Department of Primary Industries

OUT14/40922

**SIMTA Moorebank Intermodal Terminal (SSD_5056 and EPBC 2011/6086)
Response to exhibition of Environmental Impact Statement**

SIMTA Moorebank Intermodal Terminal (SSD_5056 and EPBC 2011/6086) Response to exhibition of EIS Comments by NSW Office of Water

Figure 8.11 Indicative IMT layout associated with the central rail access option (at end of Phase C) - 2030

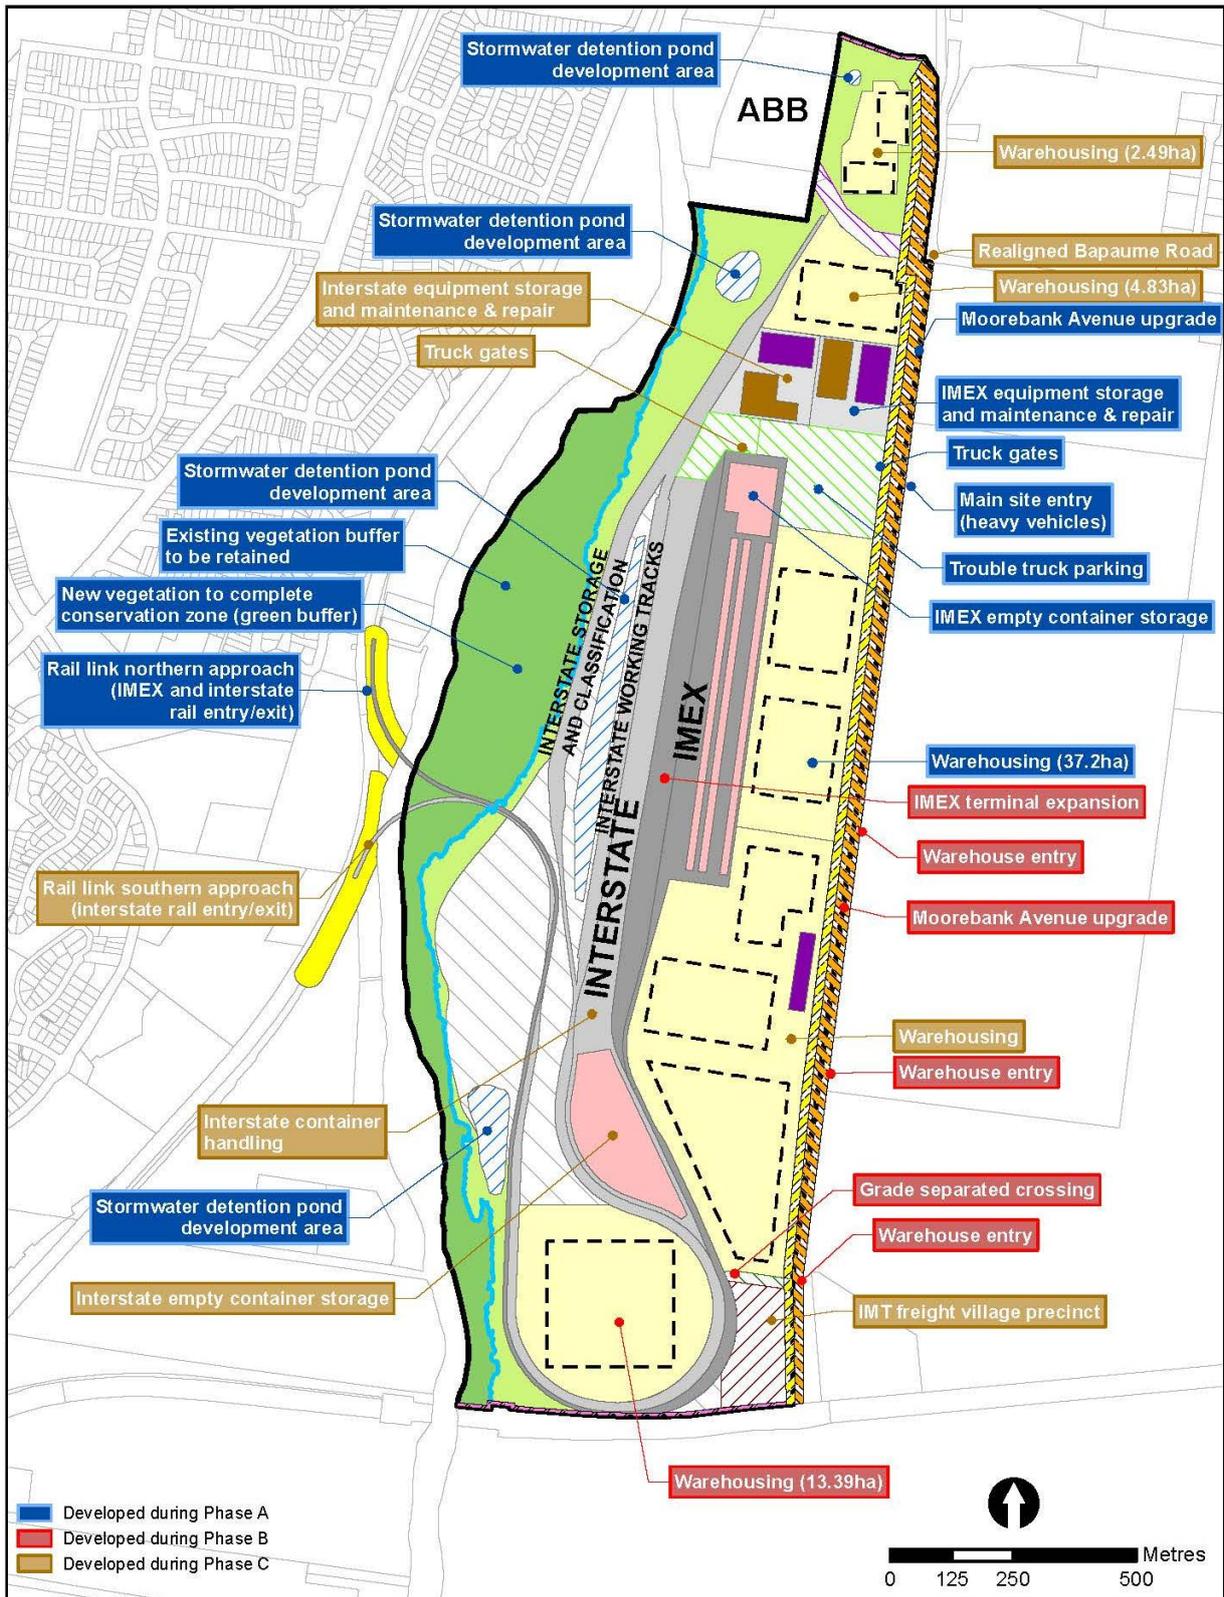
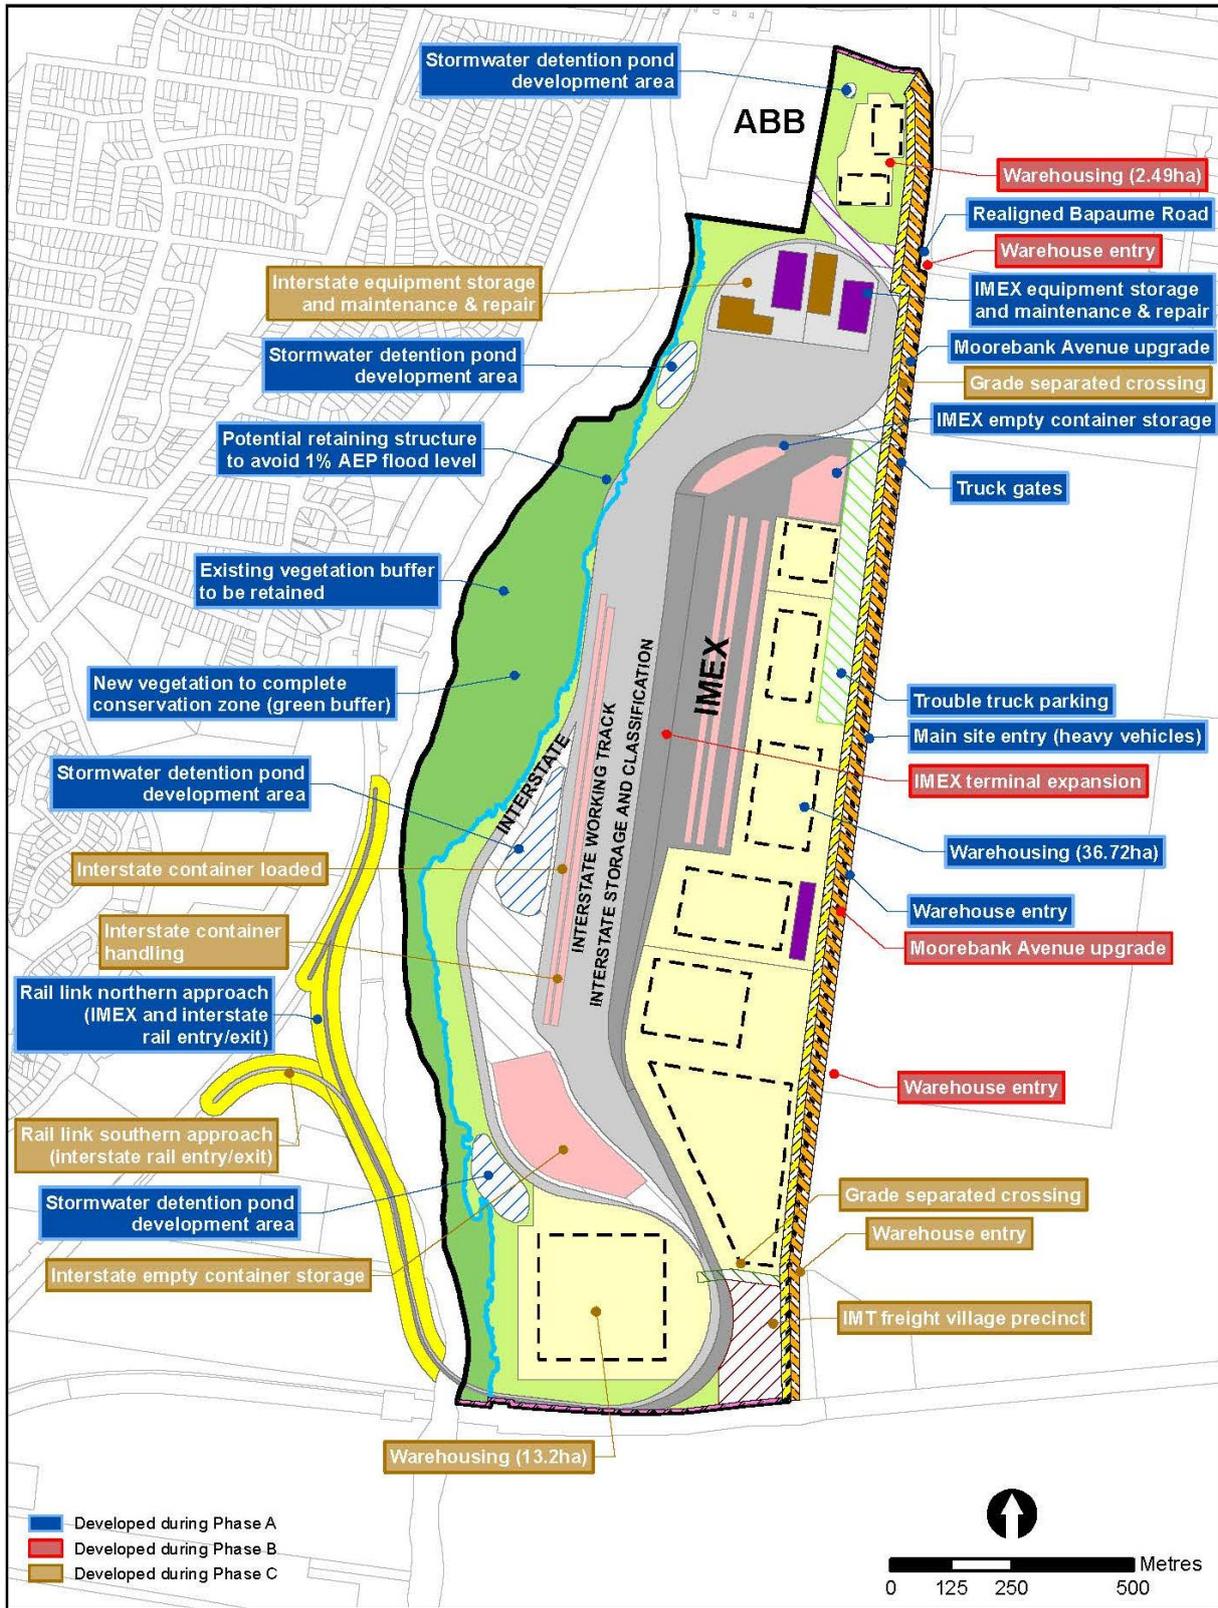
- Figures 8.4 -8.12 show a very narrow riparian corridor along the northern most section of the Georges River. The corridor width on these figures appears to follow the 1% AEP flood level (see Figures 7.2 with Figure 7.3 in Volume 1a).

- Figures 13.5 -13.7 show a wider conservation area is proposed along the northern most section of the Georges River than shown in Figures 8.4-8.12.
- Figures 13.8 - 13.10 show the proposed biodiversity offset areas are wider along the northern most section of the Georges River than the conservation areas shown in Figures 8.4-8.12.

It is recommended the figures in the EIS are amended so they are consistent in relation to the proposed riparian corridor width. Wider riparian widths along the northern most section of the Georges River are supported particularly as remnant alluvial woodland occurs in this location and Technical Paper 3 indicates riparian land within 50m of the river is considered of high value due to the function of vegetation in this area as a wildlife corridor (page 30).

Figure 23.1 Draft zoning map

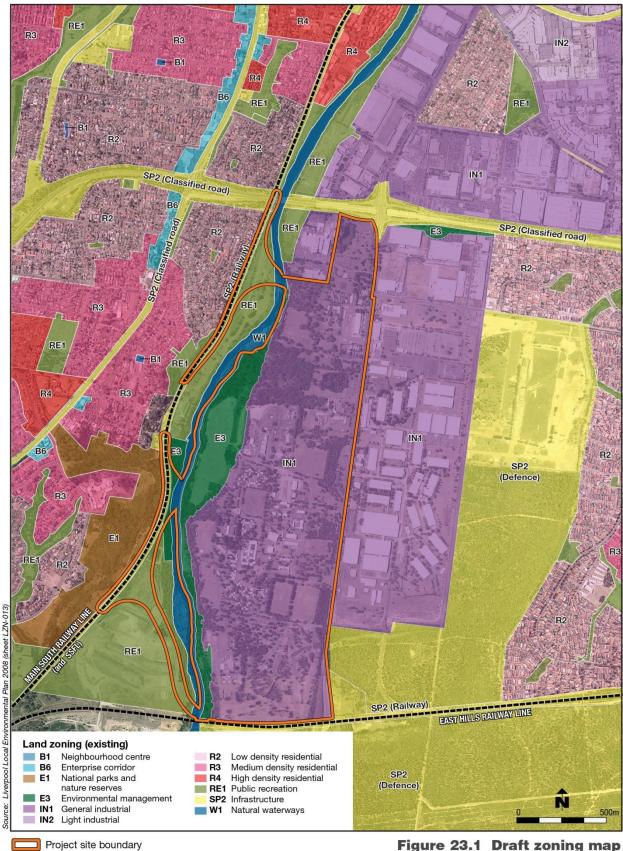
Section 23.1.7 of Volume 1b indicates the conservation area along the Georges River is proposed to be zoned E3 Environmental Management (page 7-5). It is recommended the riparian /conservation area is zoned E2 – Environmental Conservation rather than E3, particularly as the EIS indicates it is proposed to develop this land for conservation purposes.
